DRB Application No.: 03DRB-00083 (P&F) and 03-00084 (SPS)

Project Name: **EAGLE SPRINGS SUBDIVISION**

CITY OF ALBUQUERQUE
Planning Department
Development Review Board Case Comments
1/29/03

Subject: Eagle Springs Subdivision, Tract F, Lot 27-P1/ Prelim, Final Plat & SDP for S.

**LOTS 27A-P1 AND 27B-P1
EAGLE SPRINGS SUBDIVISION
SITE DEVELOPMENT / UTILITY PLAN**

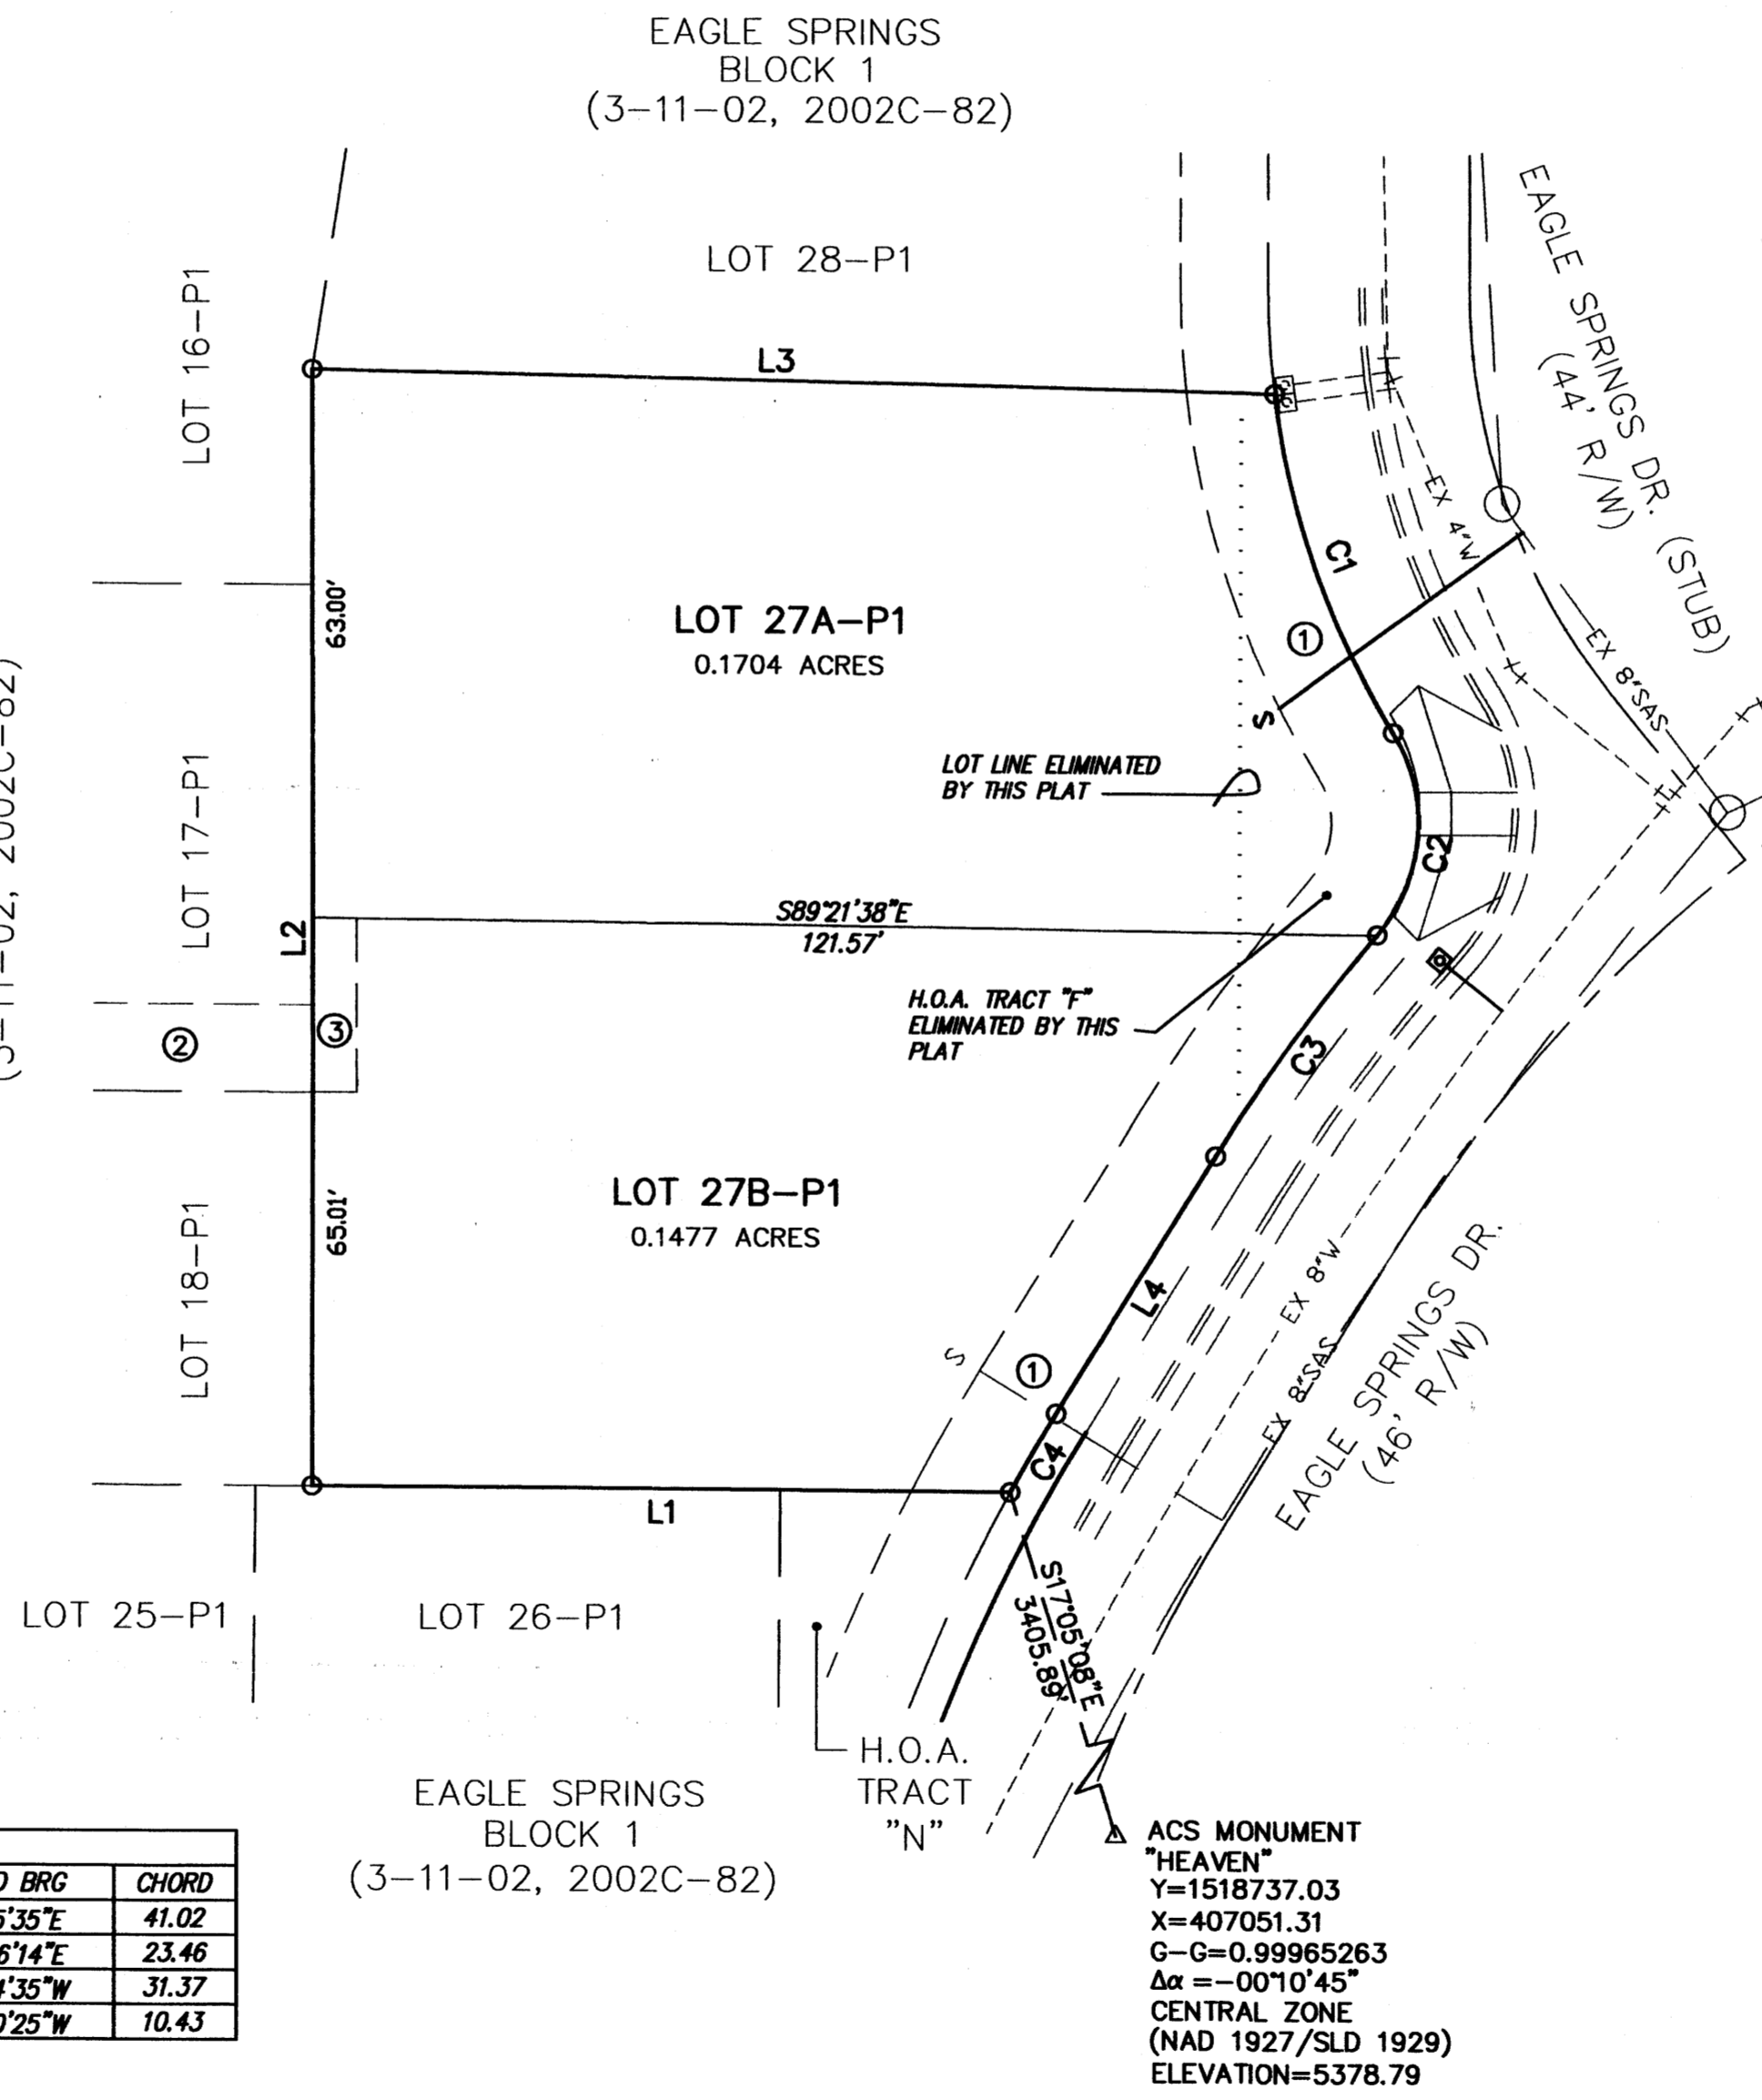
The La Cueva Sector Plan has a view preservation requirement which can be satisfied by adding a statement to the site plan:

“ This development will respect the views of the Sandia Mountains to the east and the Northwest Mesa to the west.”
